Your ref: SSD 17352813
File no: MC-21-00001

**SSD-17352814 - Huntingwood Processing Facility Expansion - 65
Huntingwood Drive, Huntingwood**

The Response to Submissions Report and associated documents have been carefully reviewed by our officers. Further to our earlier submission on this application we now withdraw our objection to the proposed development subject to the conditions outlined in Attachment A to this letter being imposed as conditions on any development consent granted.

TYPICAL HIGH/LOW FLOW DIVERSION PIT - DETAIL
SCALE 1:25

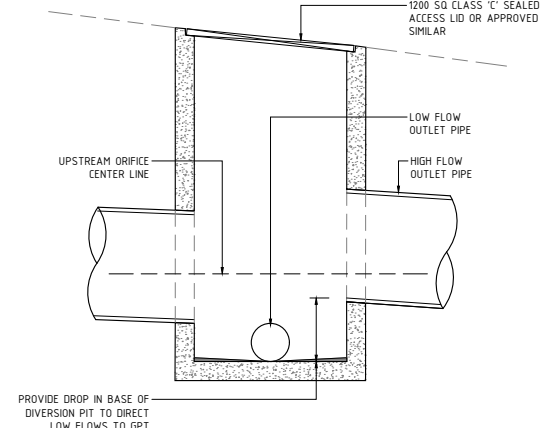
- b) Dwg. DA4702 (Rev. 2)
 - i. All diversion pit orifice to the jellyfish units are to have a Maximesh Rh3030 for <150mm dia. orifice and Weldlok for >150mm dia. orifice.

- ii. Slope the internal diversion pit to the invert of the orifice and introduce a sump just below the orifices.
 - c) Confined space entry warning signs are to be detailed on the drainage plans adjacent to all entries into the Stormfilter tank, detention tank, jellyfish tanks in accordance with Council's Engineering Guide for Development 2005.

Figure 5- Section of drawing HSK-03 showing proposed modification of the existing sewer line.

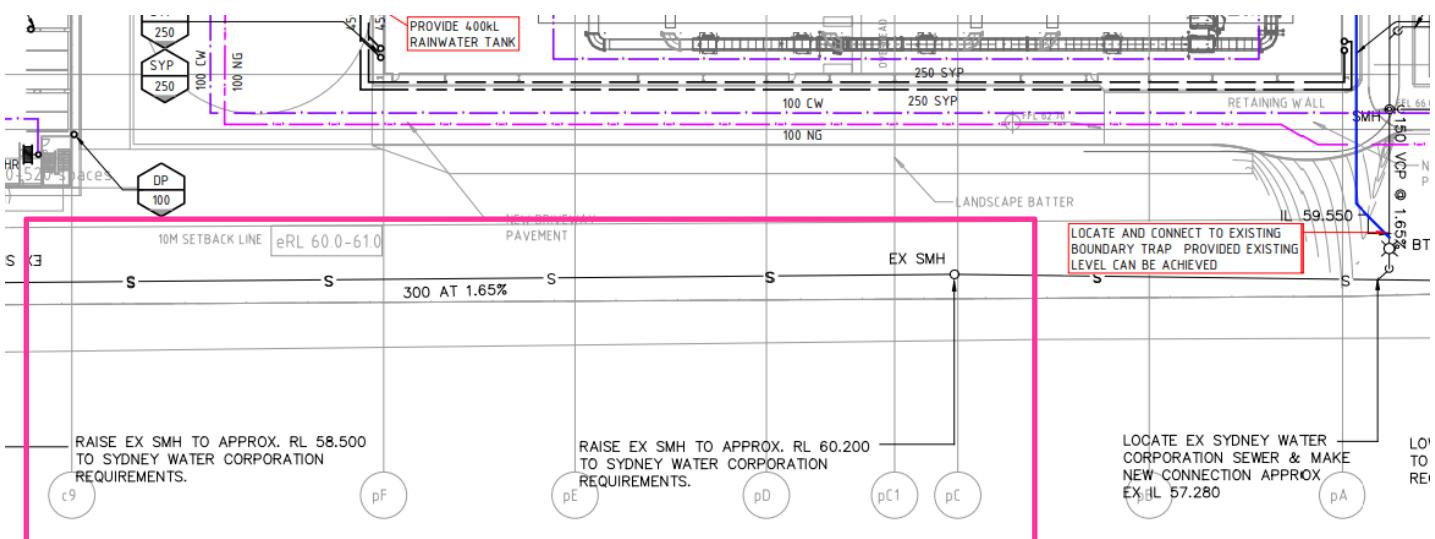
4. Where works to modify the existing sewer manholes conflict with the Tree Protection Zones of retained trees (#169 & #218), the excavation must be carried out using non-destructive means under the direct supervision of the project Arborist.

Figure 8- Tree protection fencing plan showing the approximate location of the TPZ fencing in dotted blue lines.

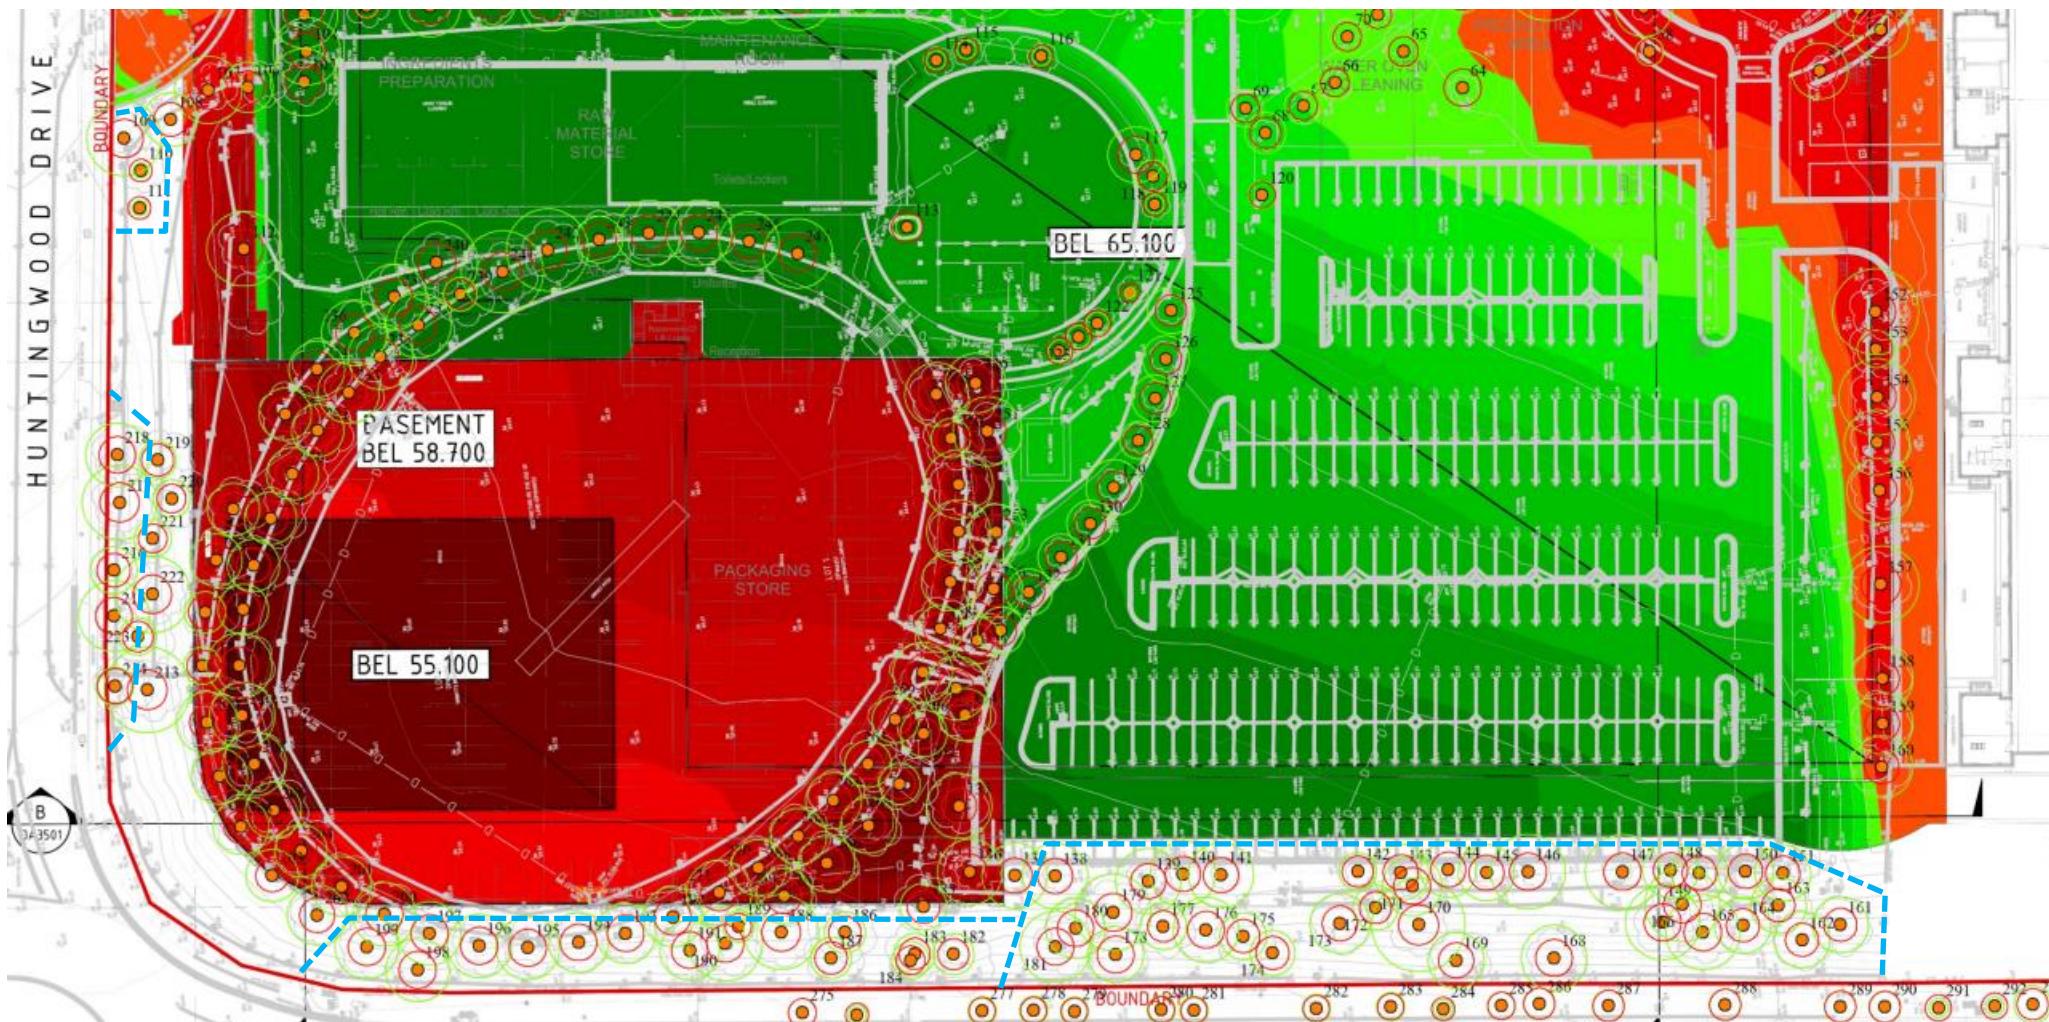
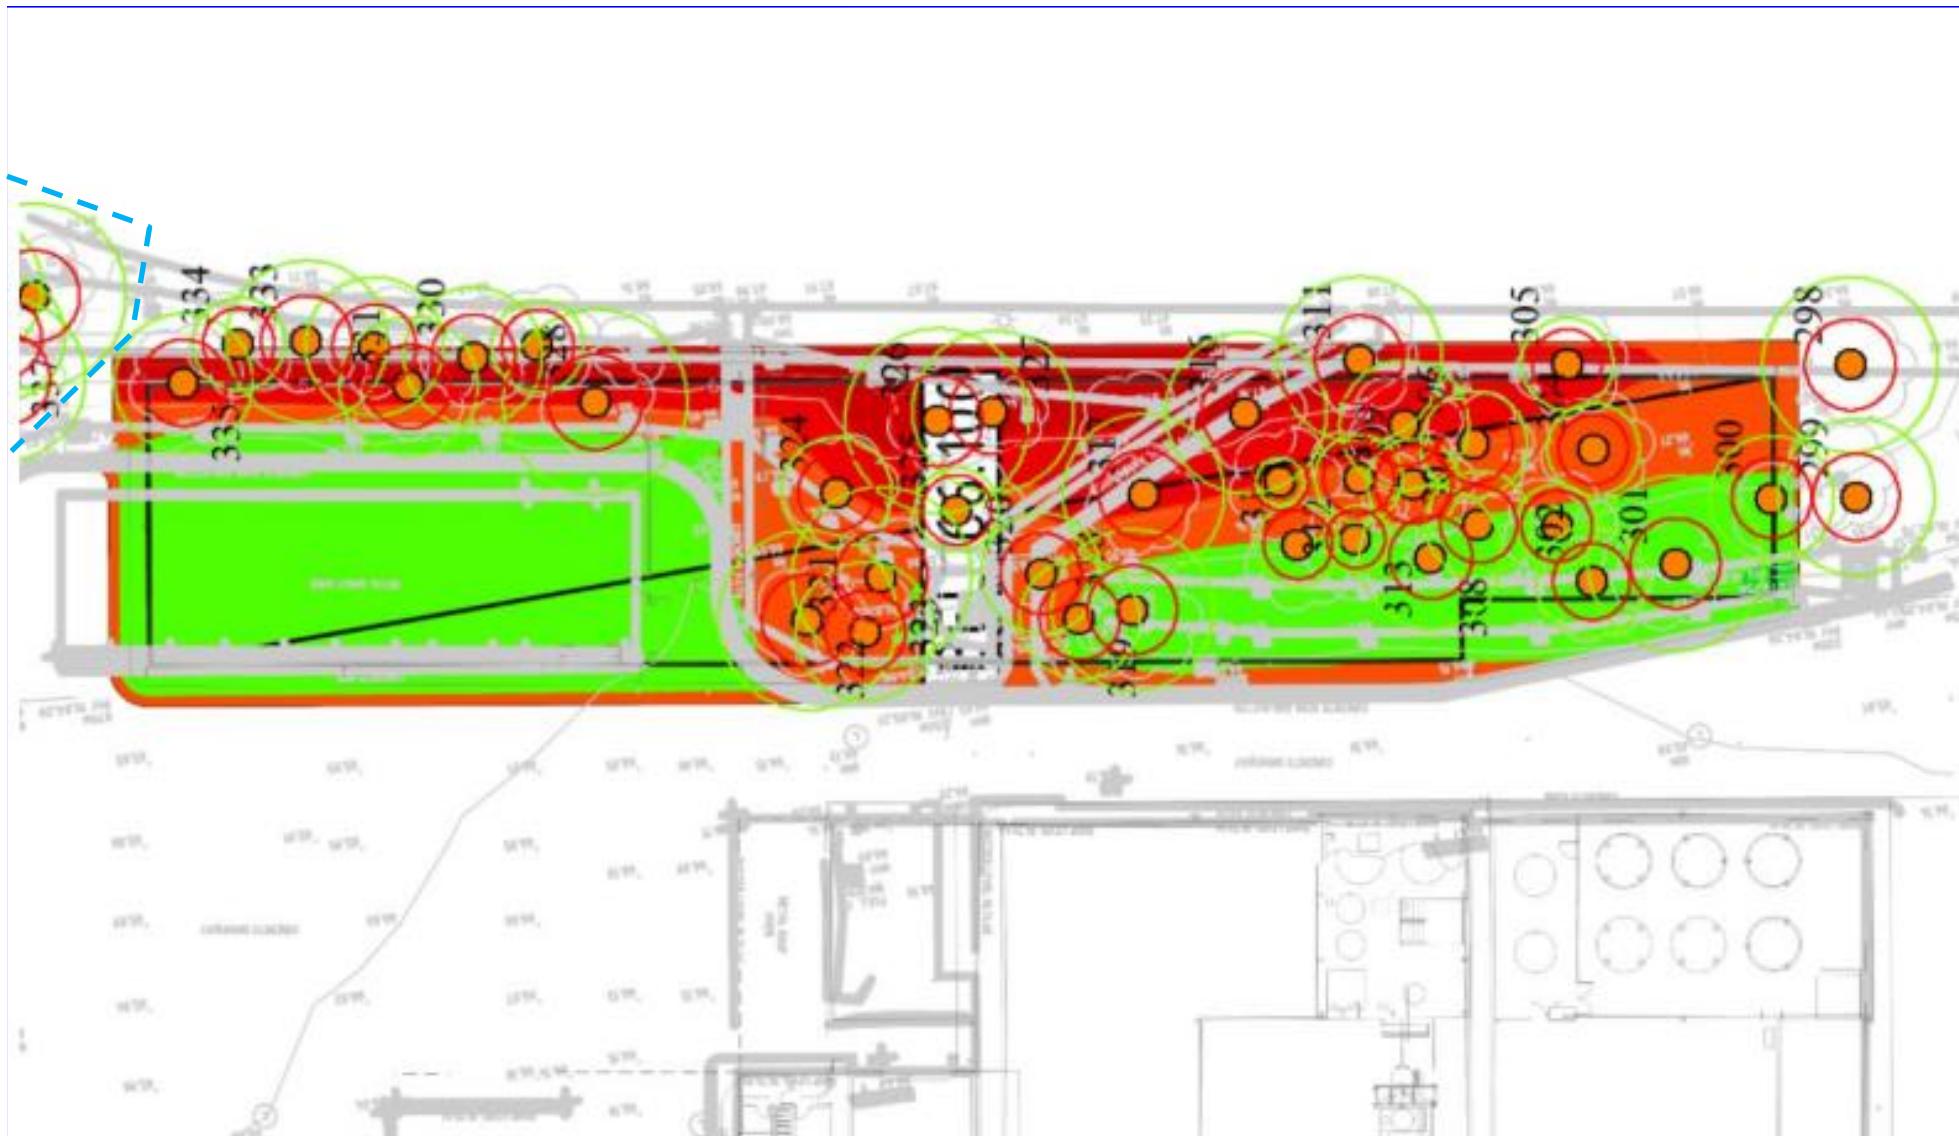
3. The project Arborist is to certify the installation of tree protection fencing, which is to be installed in the approximate locations as shown in Appendix 2 of this report and maintained in good order throughout the development process.
